Office of
Environment
& Heritage

Your reference: DA-200-5-2003 MOD 2
and 07_0127 MOD 4
Our reference: DOC14/108508-01
Contact: Terry Mazzer 6883 5302

**Re: Coalpac Expansion Modifications – Response to Submissions
(DA-200-5-2003 MOD 2 and 07_0127 MOD 4)**

OEH Review of Biodiversity Impacts

Figure 2: Cullen Valley Mine Layout with Highwall Mining

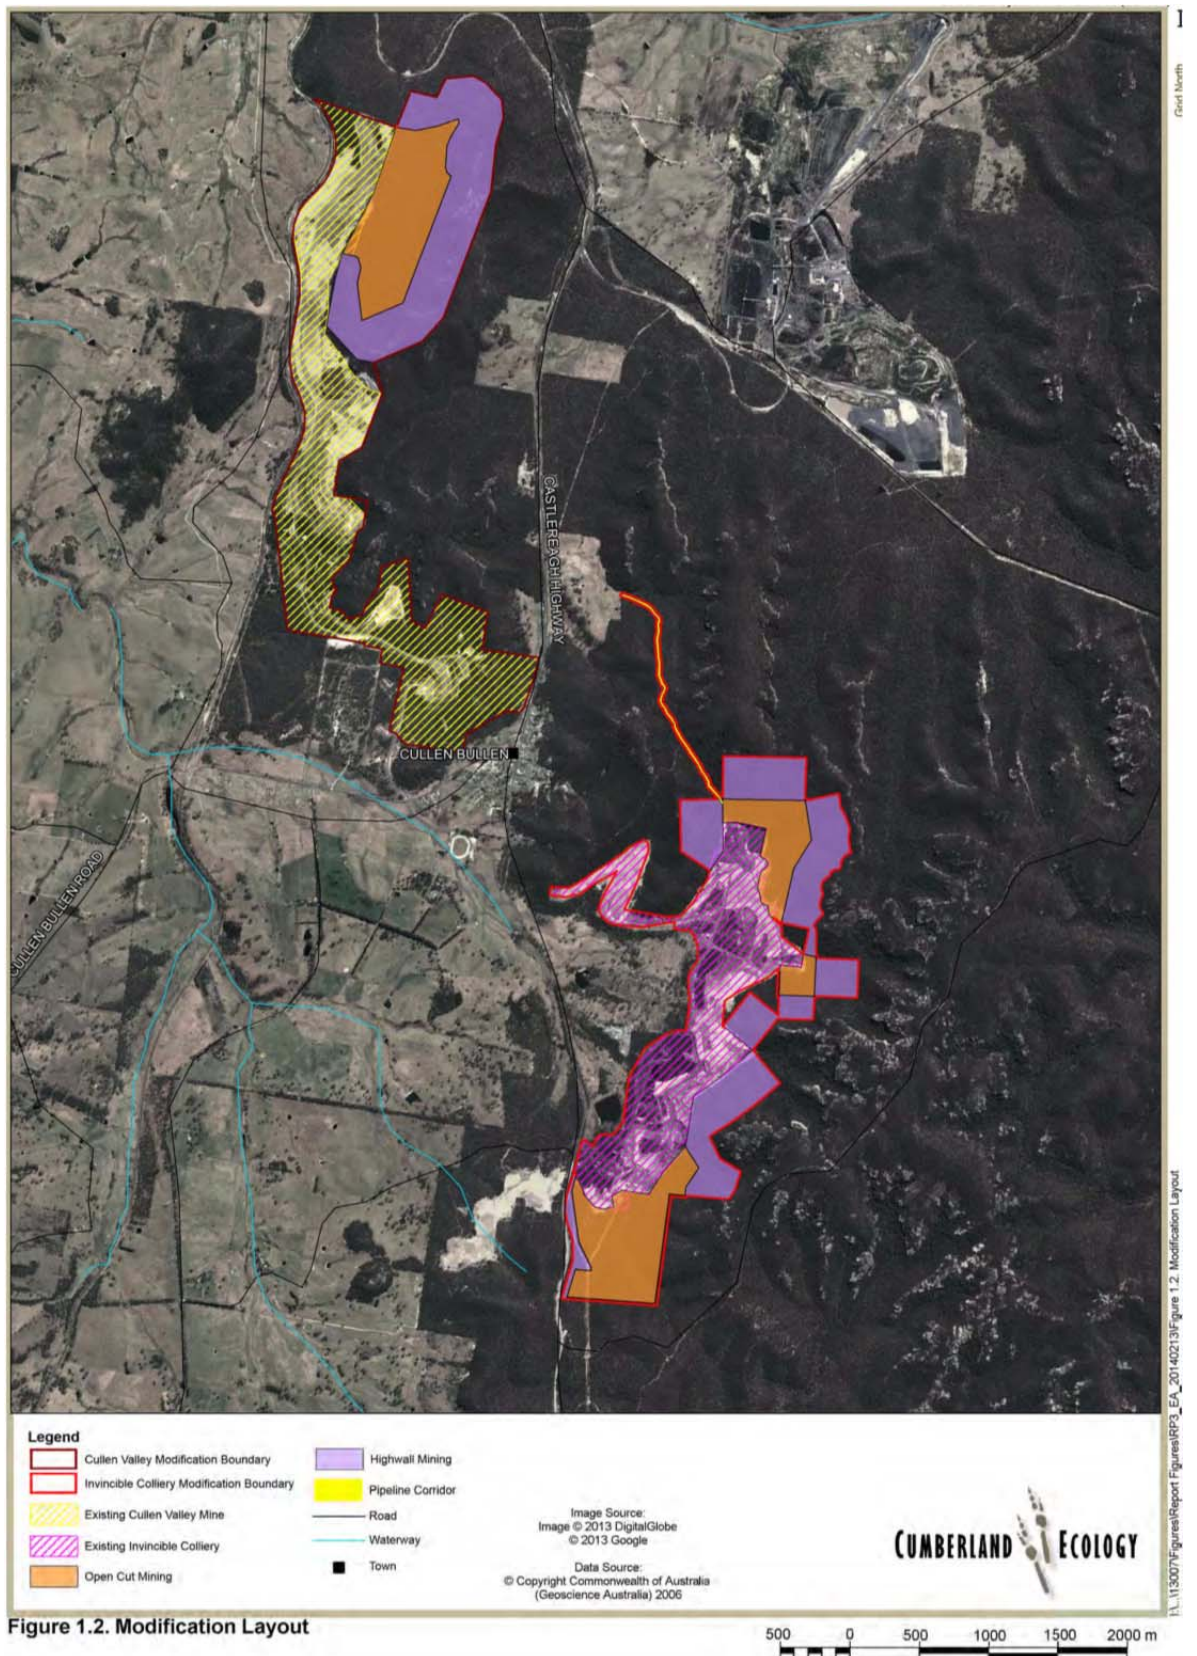
Cullen Valley Colliery: figure 2 shows that highwall mining will reach up to 200 m beneath the geodiversity features.

Figure 1: Mapped Geodiversity Features – Cullen Valley

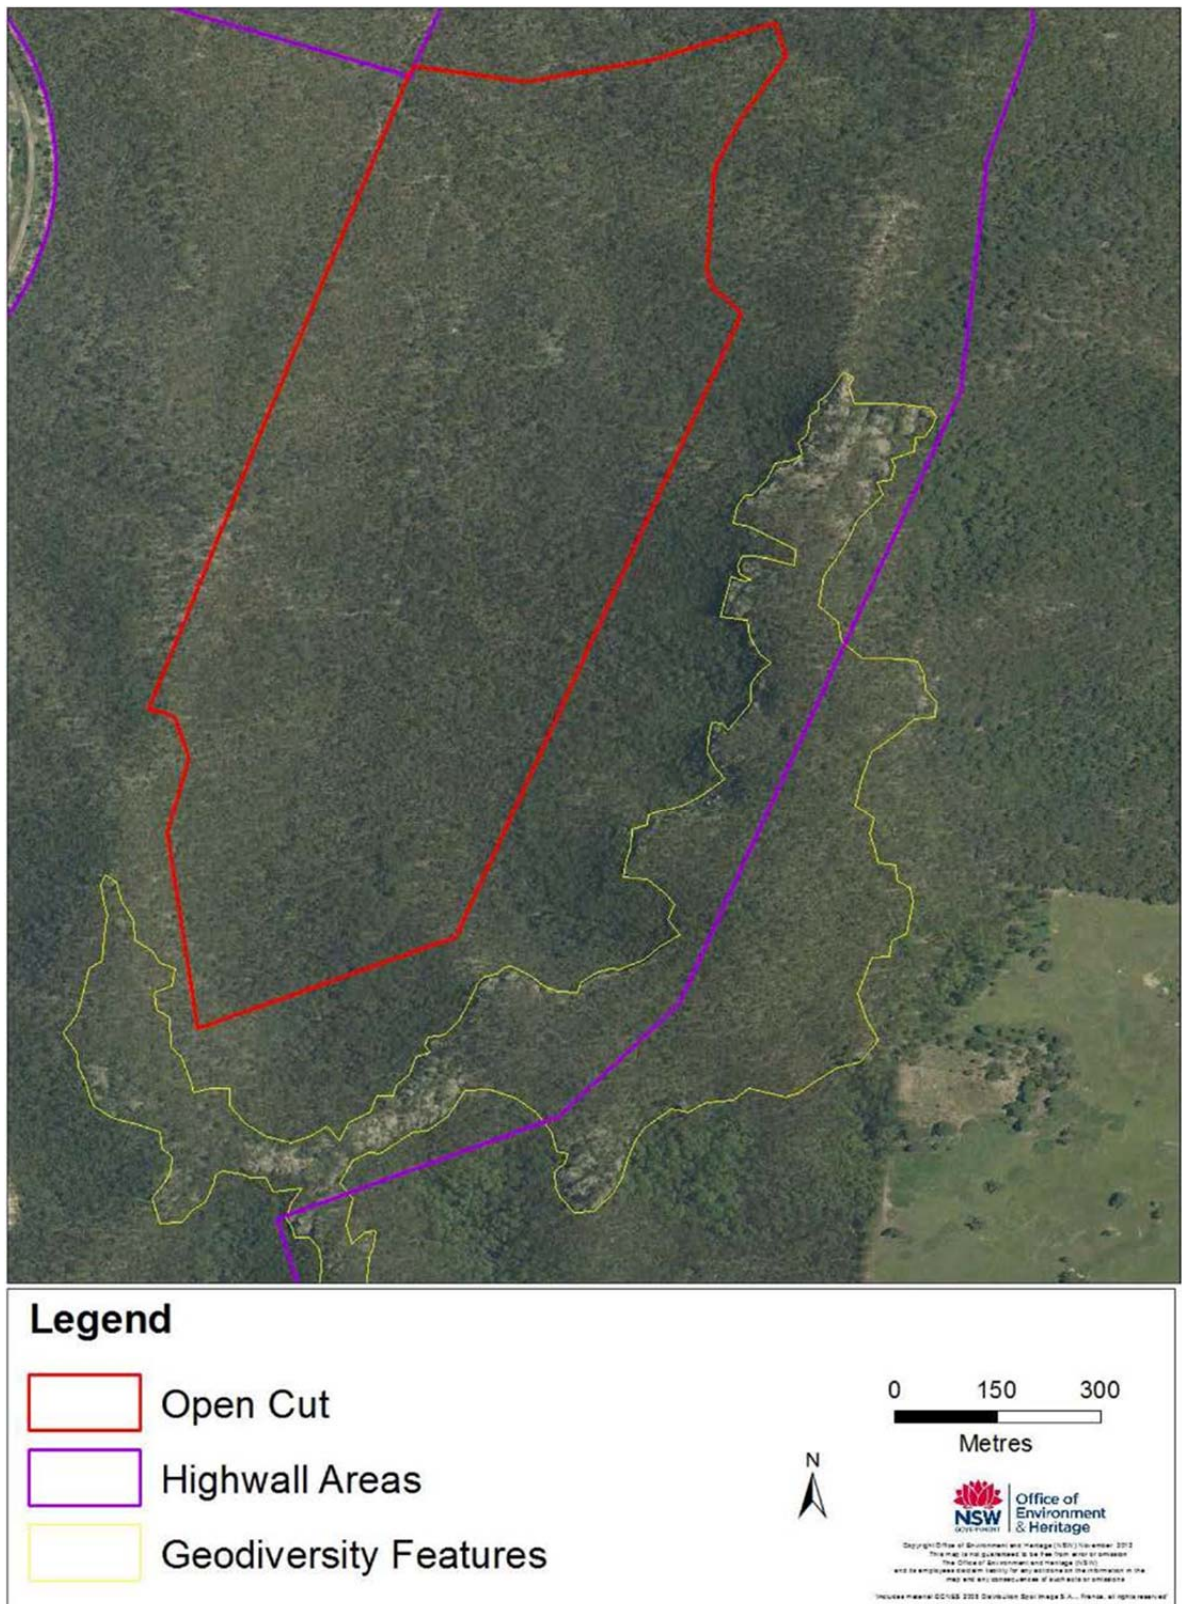
Cullen Valley Colliery: The RTS states that the open cut does encroach within 200 m of the escarpment in parts. Figure 2 shows that these extend to within 100 m of the open cut pit in at least three locations including within approximately 20 m in the southwest.

The RTS considers the Escarpment at the Cullen Valley Mine as of lesser value and less sensitive because it has an average distance between escarpment and open cut of 177 m. OEH considers this average distance to be meaningless when it can be seen that the actual distance at several points is below 100 m (figure 2).

In the submission OEH acknowledged the proposed modifications achieved this 300 m setback in most cases. However, there were some small areas in the northern part of the Invincible modification where the setback was as small as approximately 100 m and much of the open-cut area proposed for the Cullen Valley modification was within 100 m or less of sandstone escarpments (see figures 1 and 2).
